From: Lisa Hughes
Sent: 01 March 2010 18:53
To: Planning
Subject: FW: S6/2010/0134/FP

Sent: Monday, March 01, 2010 2:20:27 PM
To: Peter Jefcoate
Subject: S6/2010/0134/FP
Auto forwarded by a Rule

I wish to comment on the above Application.

WOODFIELD LANE ELEVATION
PROPOSED NEW RAILINGS
1:75

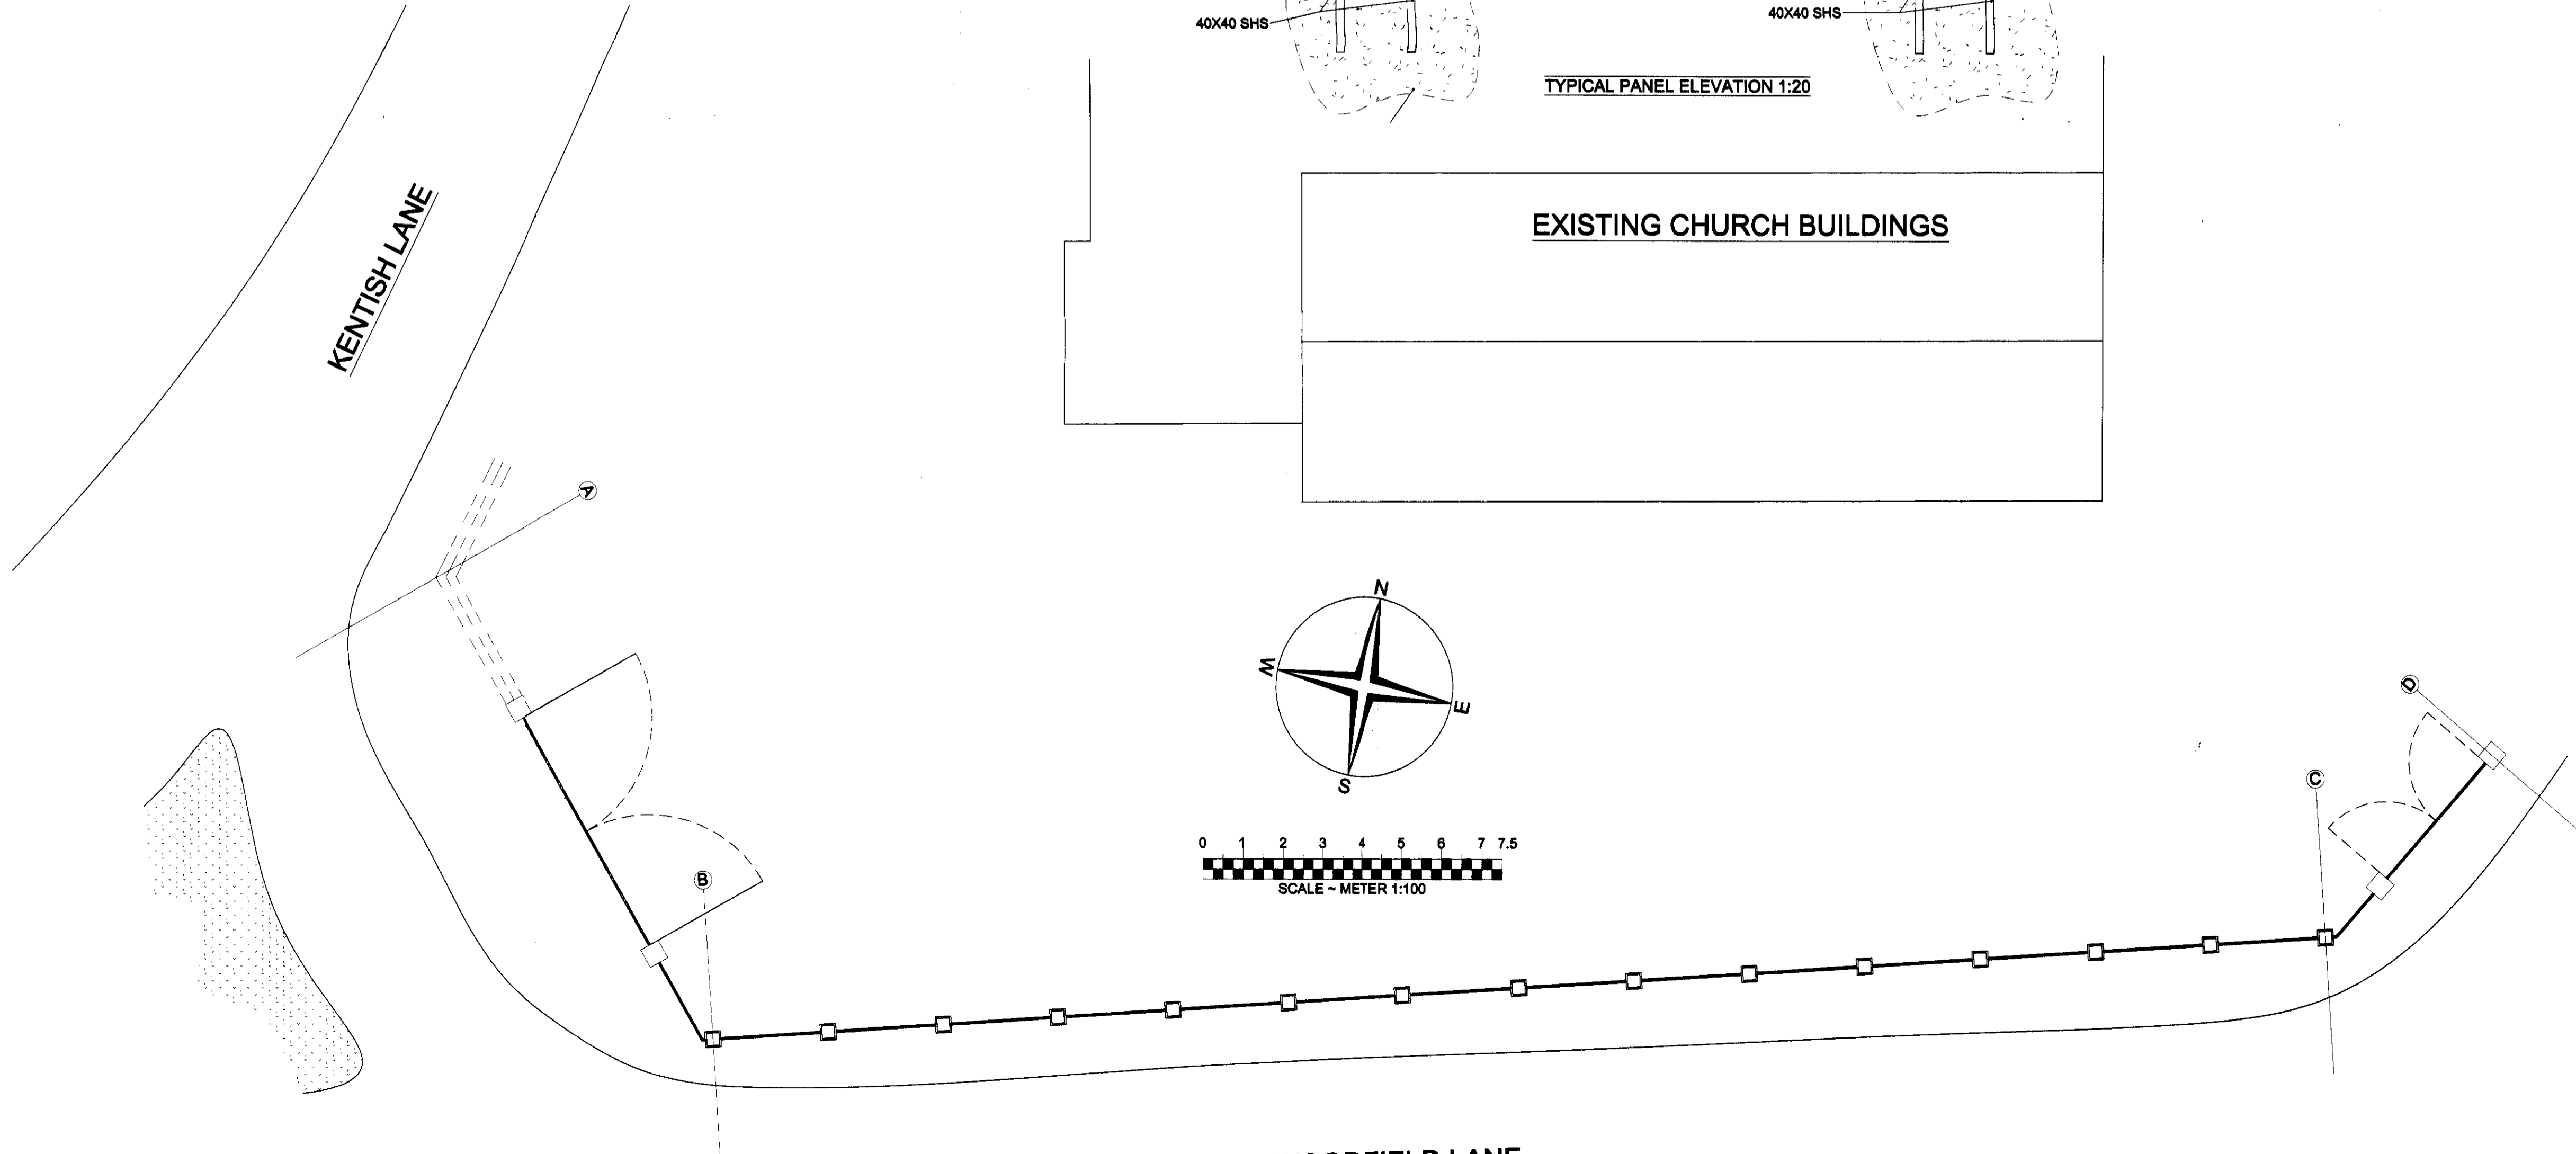
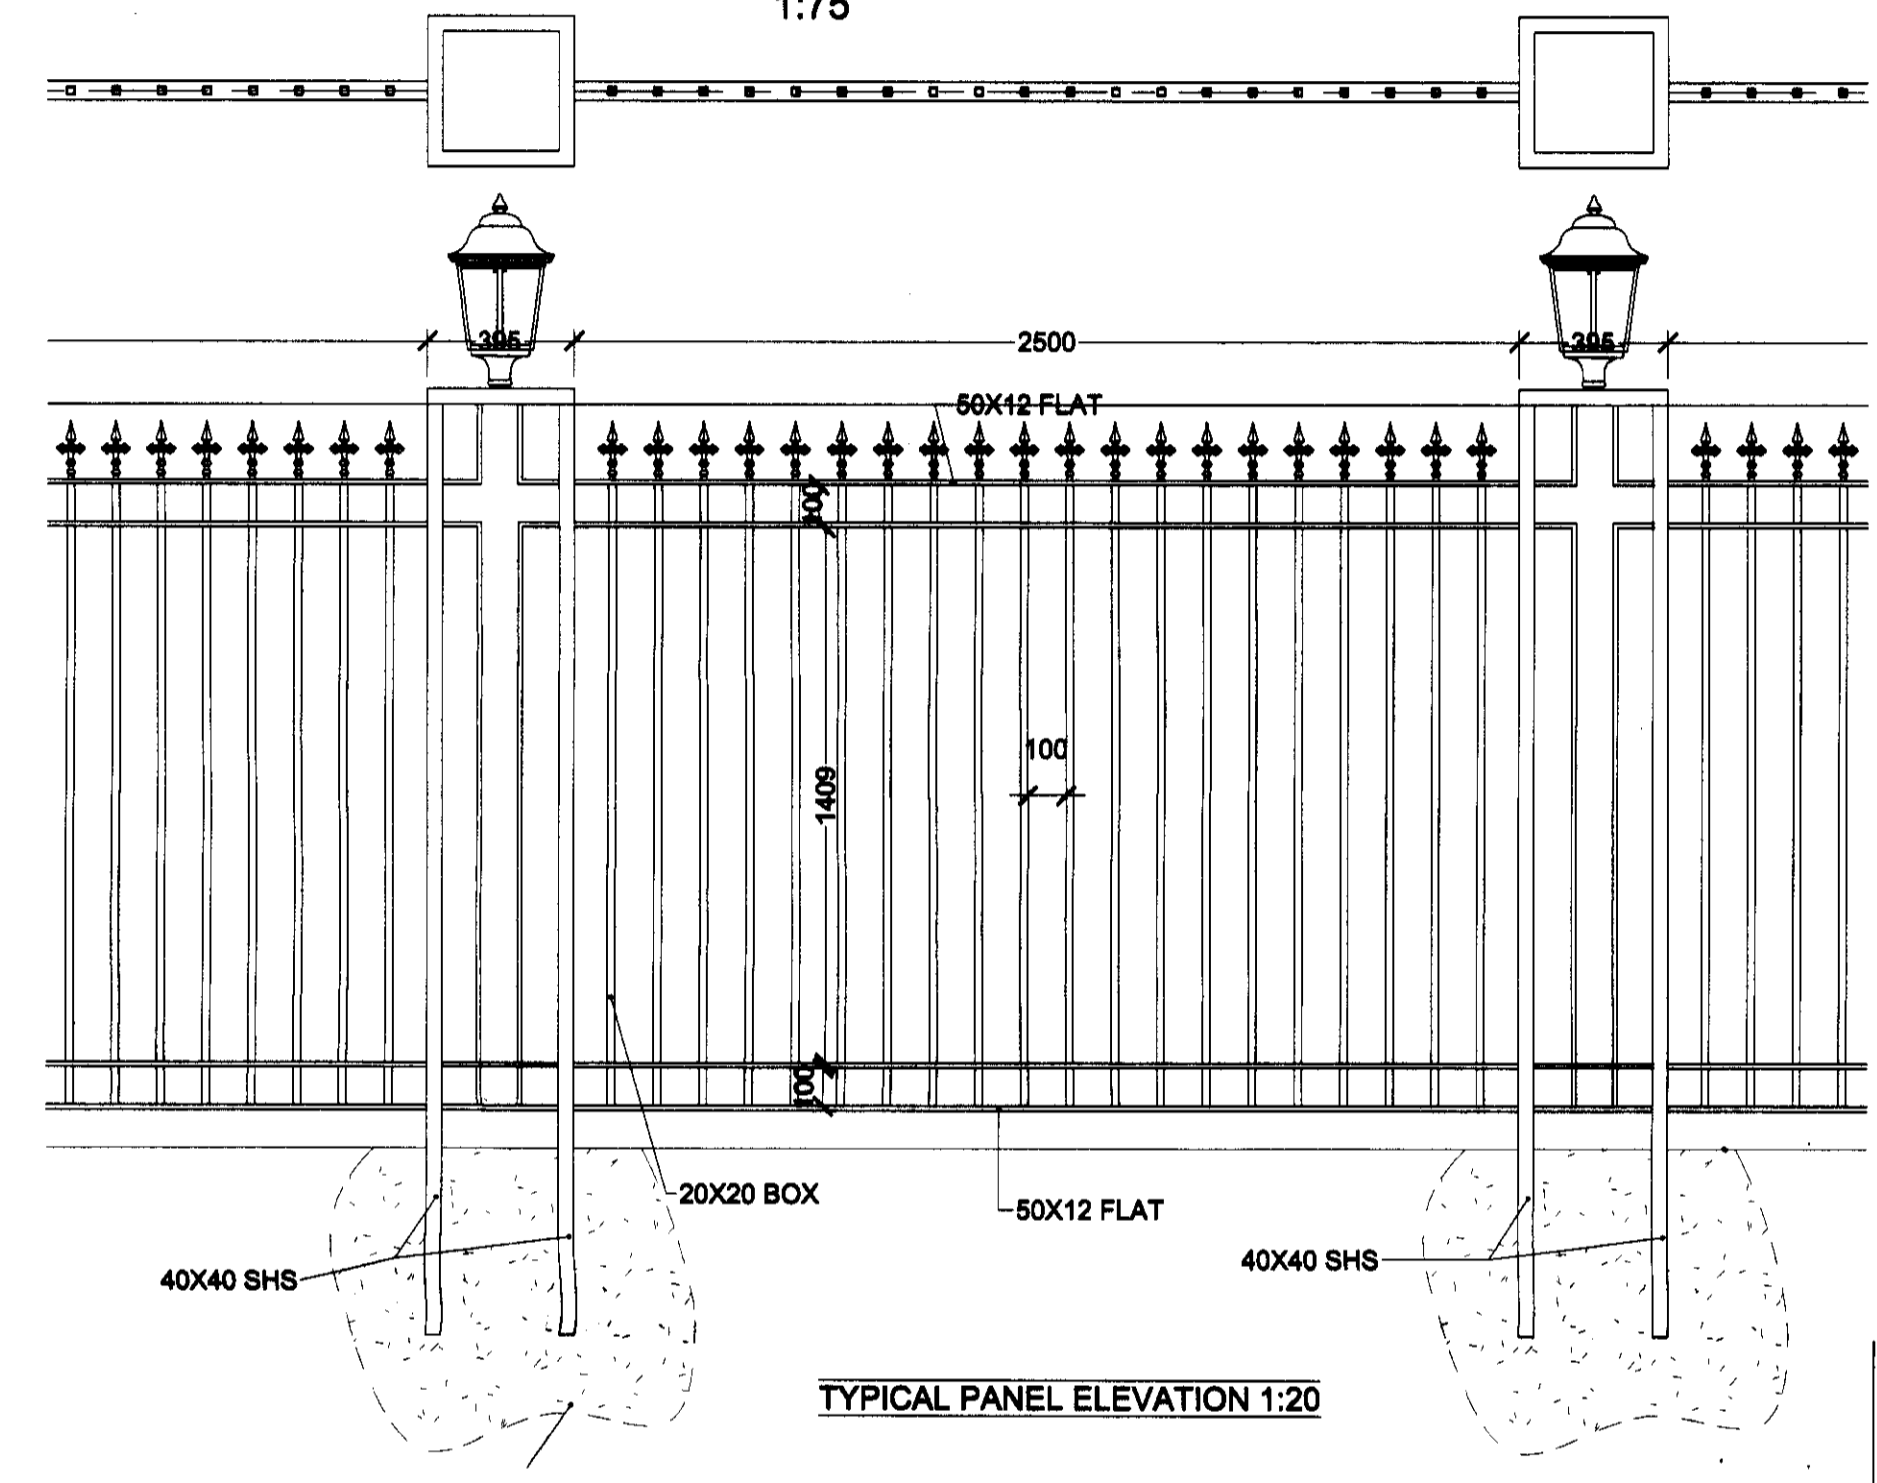
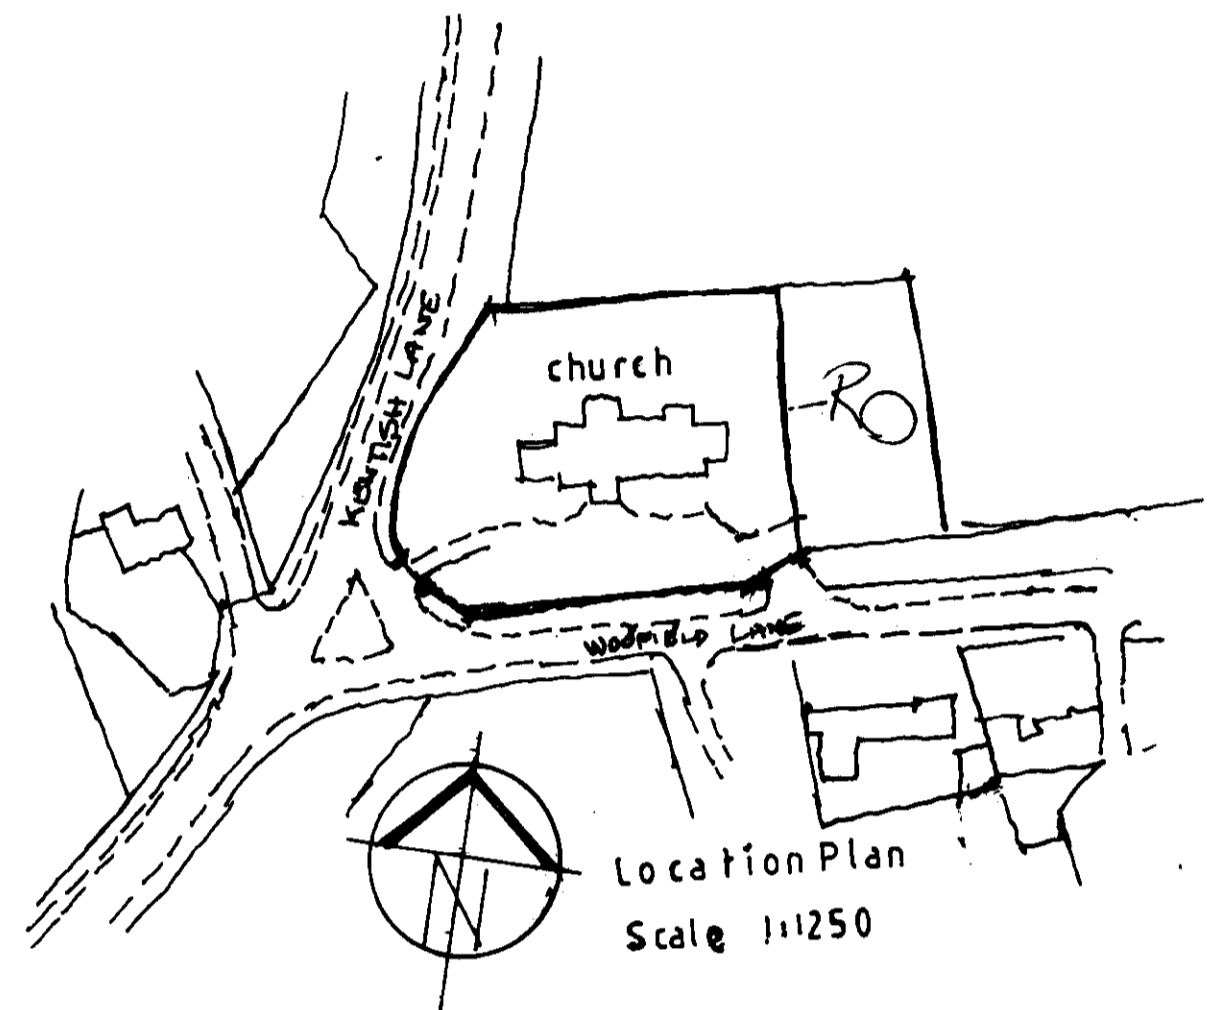
- 1 The description of this Application as 'Replacement fencing to Boundary' appears to include the demolition of the length of brick and flint boundary wall facing Woodfield Lane and replacement with metal railings.

- 4 The removal of the existing wall to Woodfield Lane and replacement with railing will remove the element of visual screening provided to the car parking area .

- 5 The proposed metal railings are of an urban design totally out of keeping with the rural setting of the site and do not either preserve or enhance the area They do not relate to the materials of the Church Building which is built of flint with brick and stone dressings and a clay tiled roof. The proposal for lanterns atop the posts at 2.5metre centres will be unnecessarily intrusive by day and especially at night.

6. I recognise that while the building and wall which date from c.1875 are not Listed, it may be appropriate for advice to be sought on Conservation Matters . The removal of a section of the boundary wall will remove an important element from the landscape of this area.
